12/02/2021

**Alterations and Additions to President Private Hospital (SSD-10320)  
Response to Submissions**

Basement Plan - Hotham House Retained

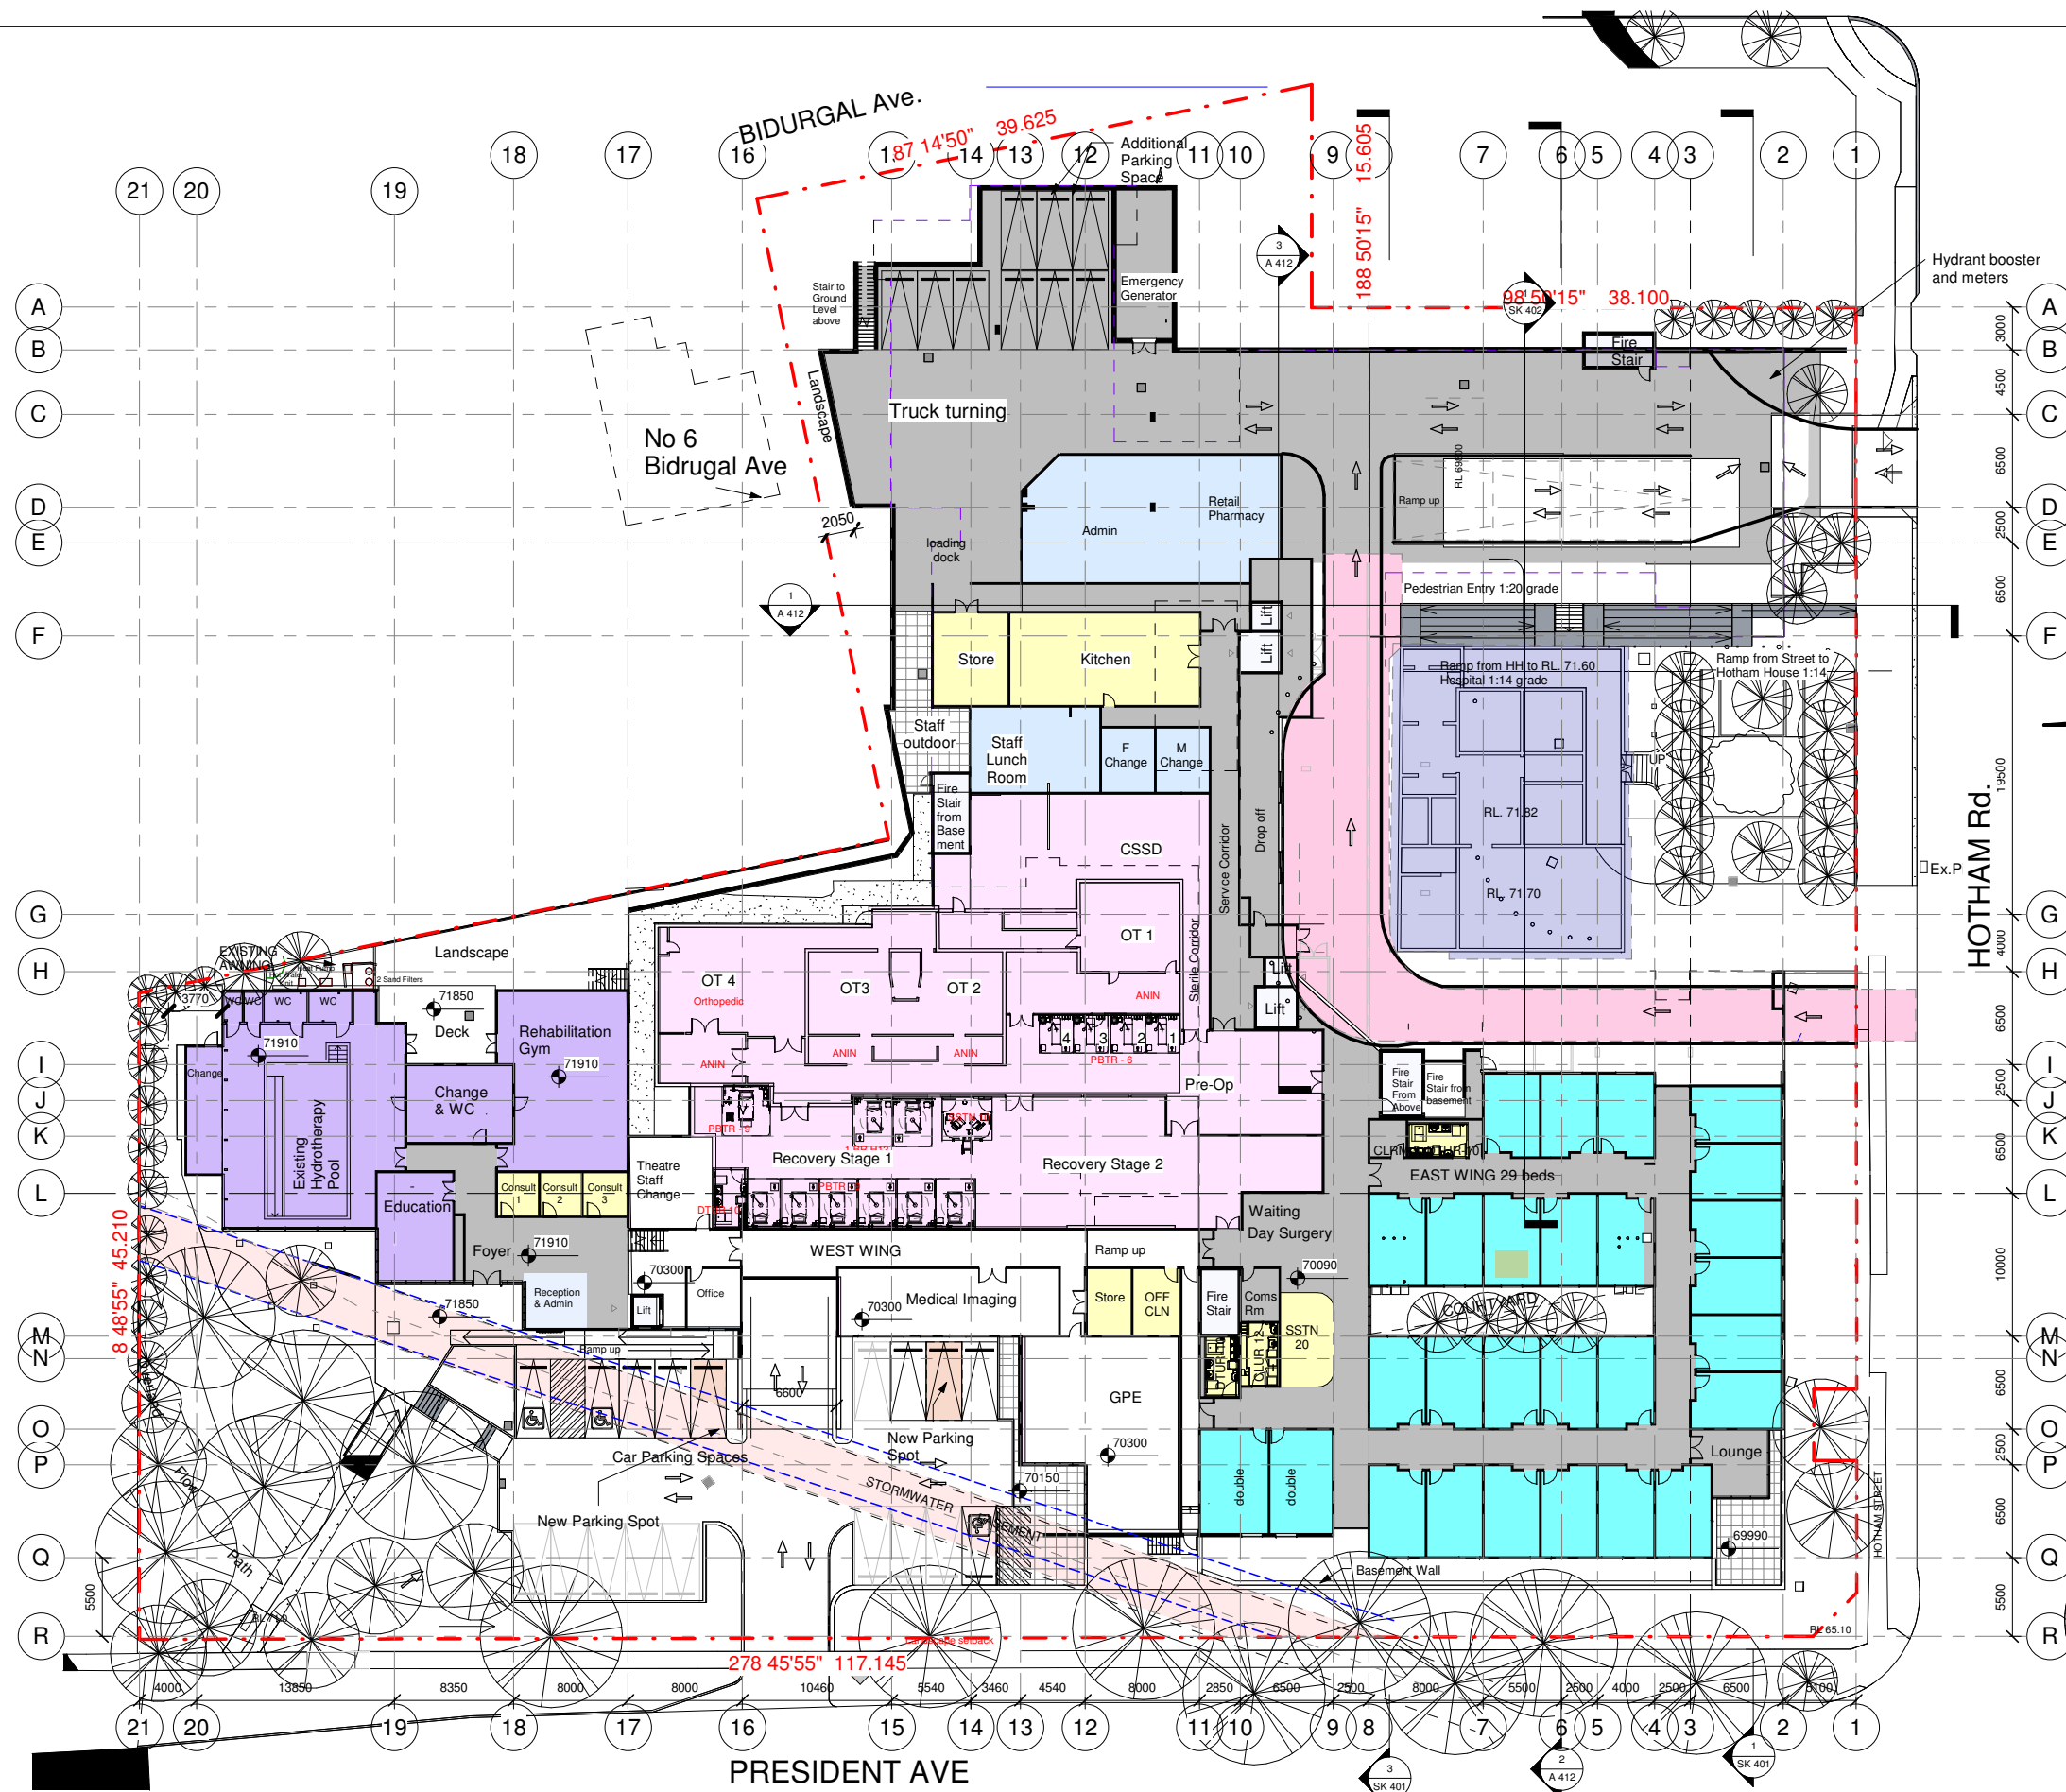
- Hotham House was only recently listed in Sutherland Local Environmental Plan 2015 as a local heritage item and is highly regarded by the local community. Opportunities for the inclusion/retention of Hotham House (i.e. adaptive reuse of the building) in the overall design is to be further investigated and presented demonstrating, through revised schemes, that all options have been considered.
